# FINAL DRAINAGE LETTER FOR LOT 7 OF CLAREMONT BUSINESS PARK 2 FILING NO. 1

## EL PASO COUNTY, COLORADO

Project #44-037  
PCD – SP 20-000

PCD File No. PPR2030

**FINAL DRAINAGE REPORT  
CLAREMONT BUSINESS PARK 2 FIL. NO. 1  
PROPOSED DRAINAGE MAP**

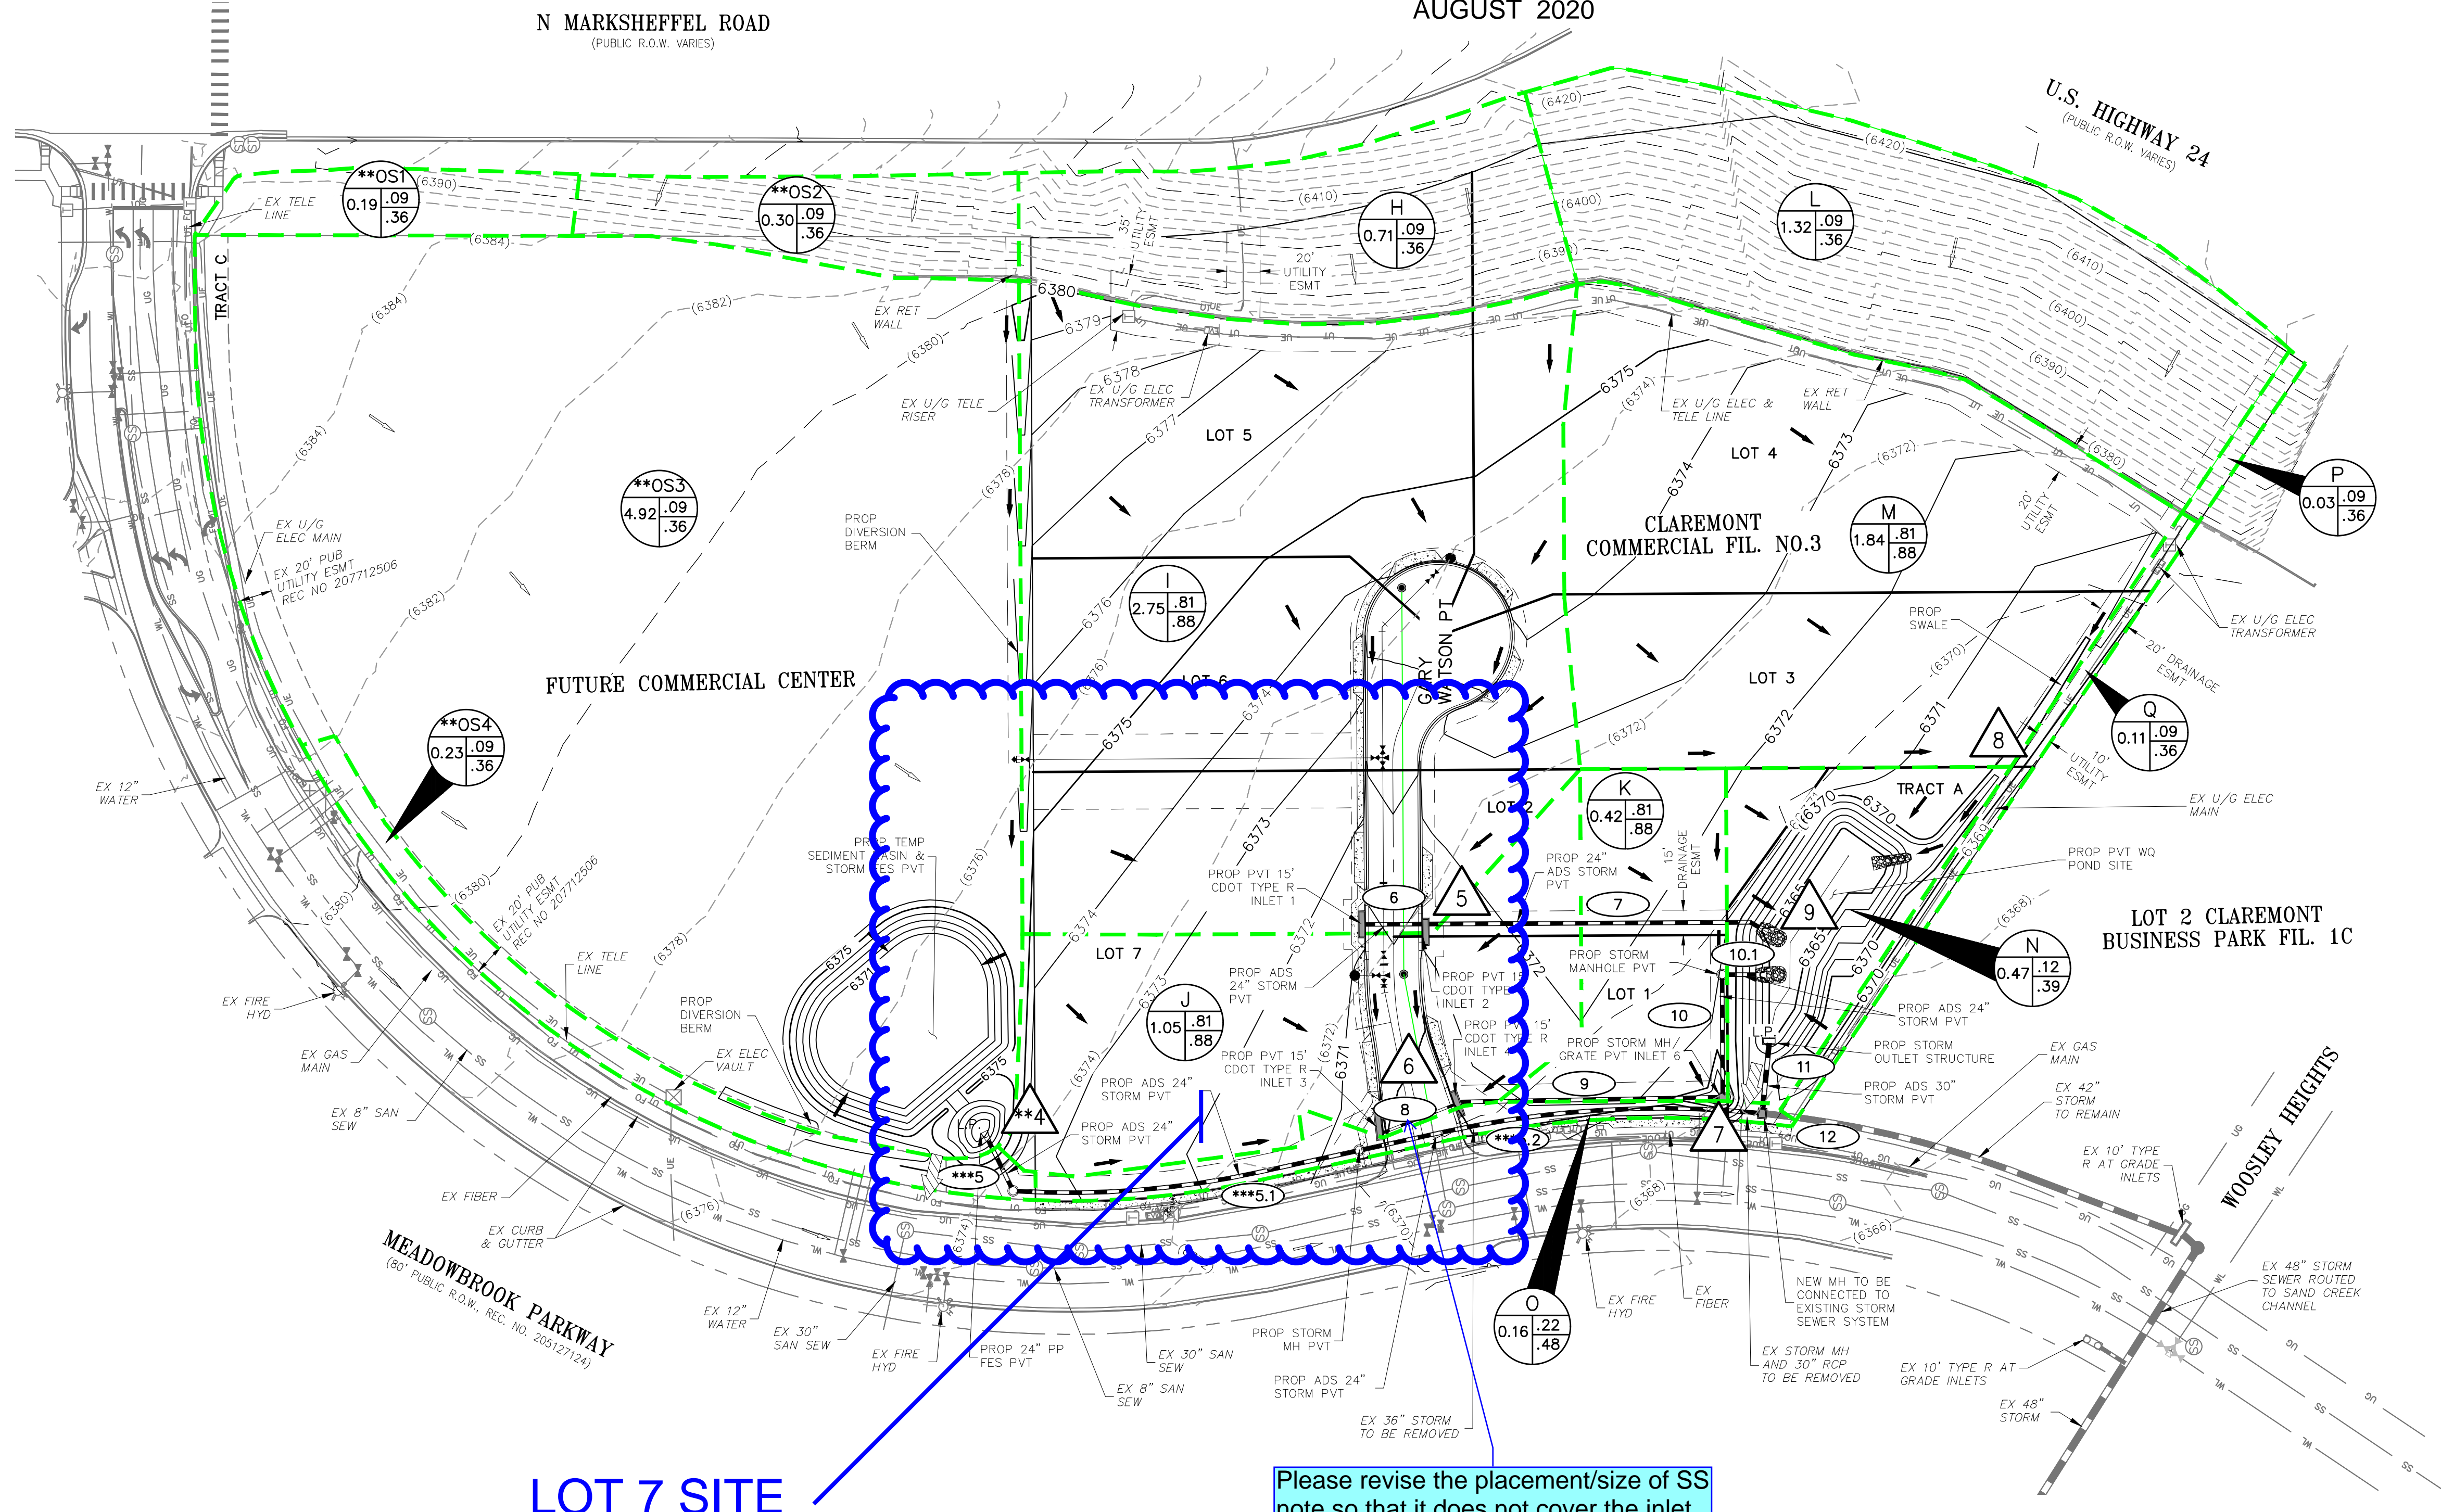
Please provide a site specific drainage plan with the proposed building and flow arrows.

Please move maps to the end of the report for review purposes.

Please revise the placement/size of SS note so that it does not cover the inlet.
